Application No: P/161/21/HH
Site Address: 21 Pyrford Close Pagham PO21 3NL
Description of works: Erection of single storey rear extension, front porch, detached garage to side, shed in rear, conversion of loft to habitable use and alterations to fenestration/openings following the demolition of existing rear conservatories.

Thank you for your internet representation made on 22nd December 2021 which has been recorded as an objection with the comments as follows:

OWPC42838

W Elevation proposed
1 : 100

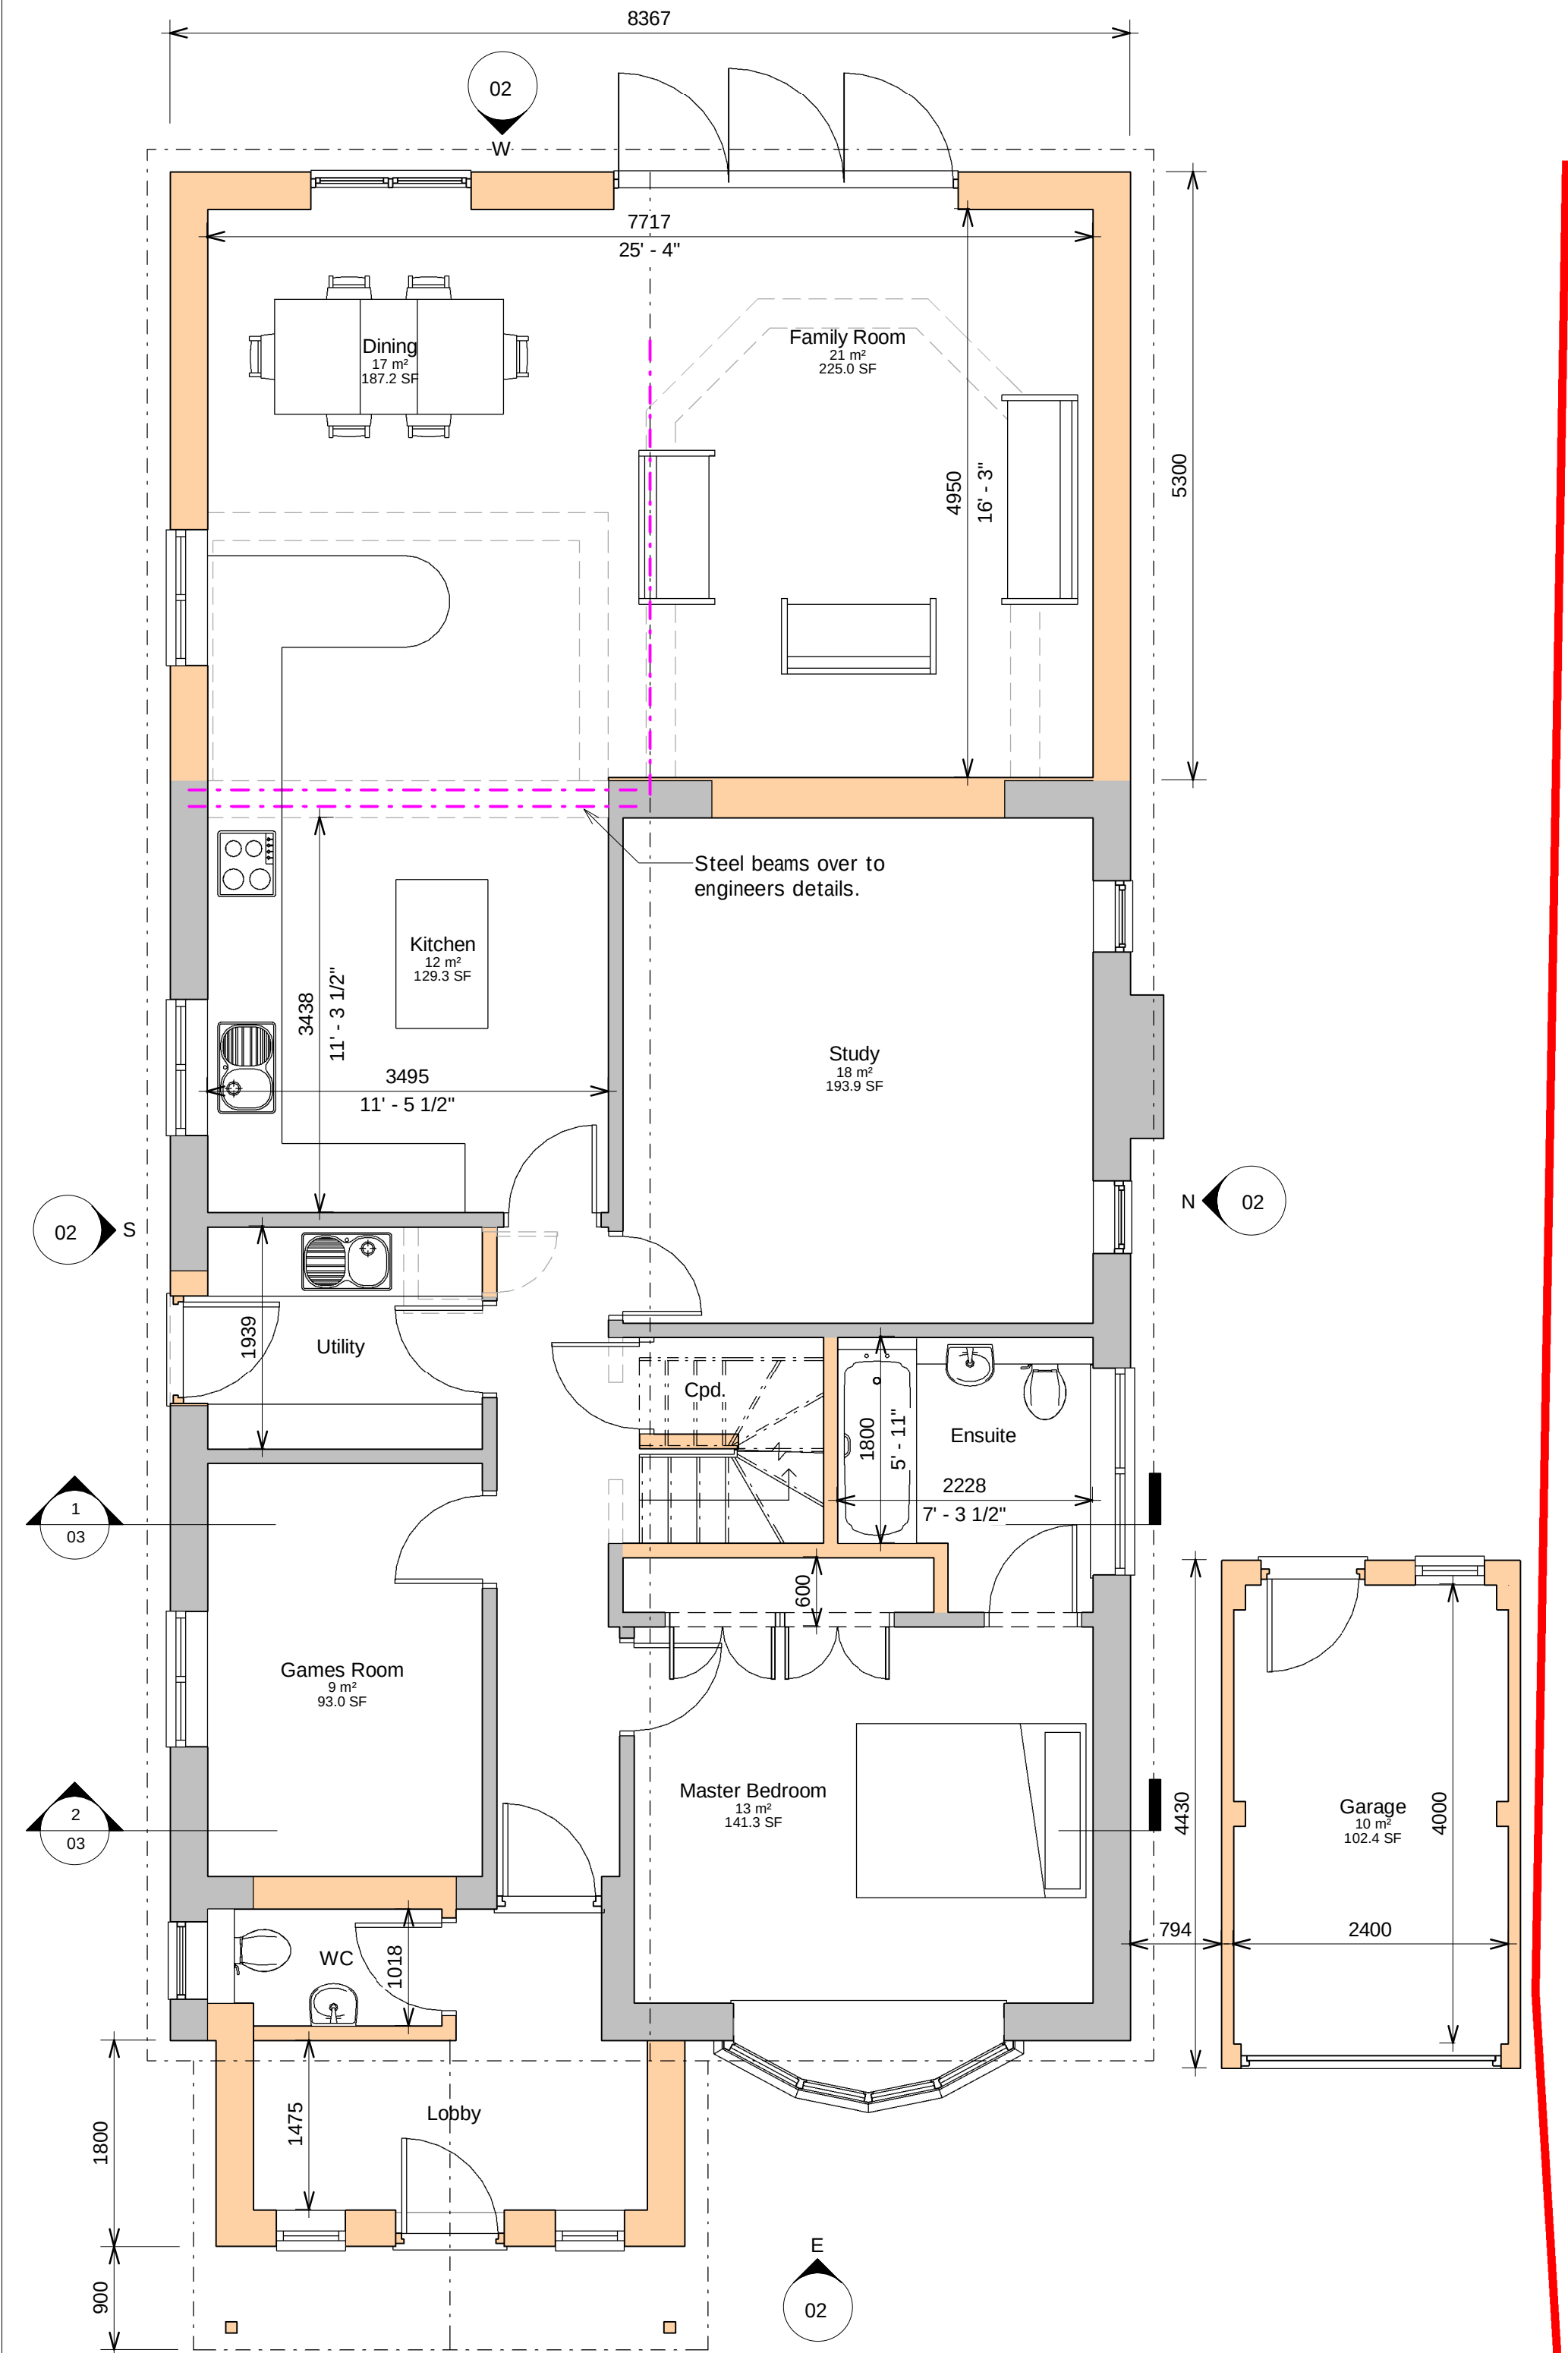
Our objection is against the proposed 'Garden Shed'. The main reason is the size and scale of it. It seems very excessive for a garden shed. The overall height of 2.55 metres, in our view, over exceeds the height of any normal flat roofed garden shed. It also means that 2.5ft of the wall and roof of this will be visible over our fence. It's bigger than the proposed garage wall height? It will overshadow one side of our garden and block out light.

We are concerned about what the shed is going to be used for and potential noise from it as a standard garden shed does not have patio doors nor is it to this scale. There are also no mentions of materials being used on the outer skin which will be on total view when we look into our garden.
